23rd October 2023

Planning Application reference 3/2023/0707

Application to regularise mixed building use permitting retail with associated bar serving alcohol and occupational dwelling (sui generis)

1 Lower Lane, Longridge, PR3 3SL

Existing and Proposed Ground Floor Plan

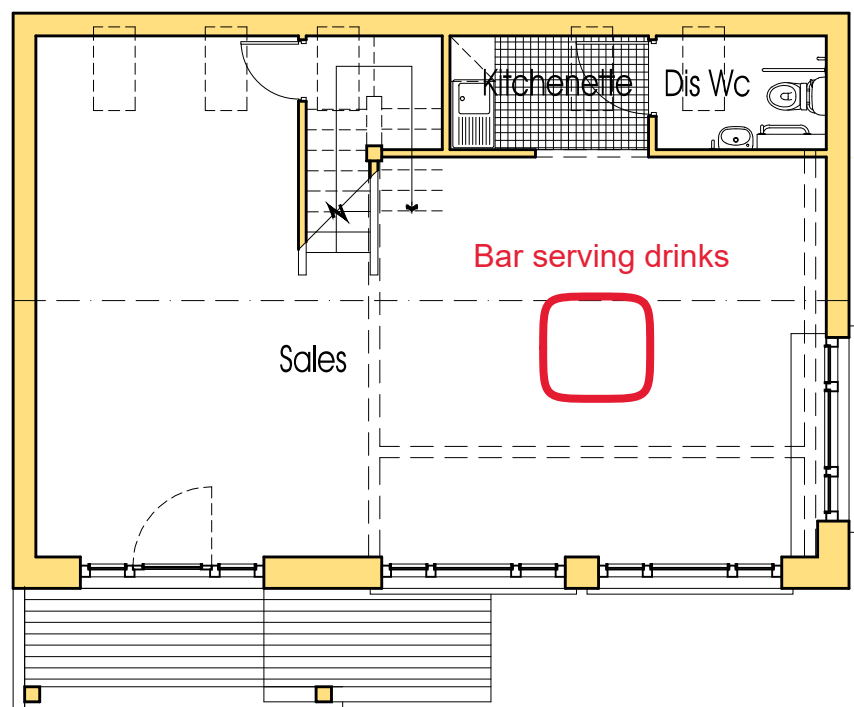
- 1) It would appear that the use of the bar is the primary function of the building, it is not ancillary to the retail and interior design use. This is reflected in the amount of space the bar (parties/functions) takes up within the property and the overspill into the area marked as 'sales' on the submitted plan.
- 2) The application does not include the live music/functions/parties (including catering) which take place on regular occasions (see list of records kept at appendix 1 from January 2023 to when the temporary stop notice was served in August 2023)
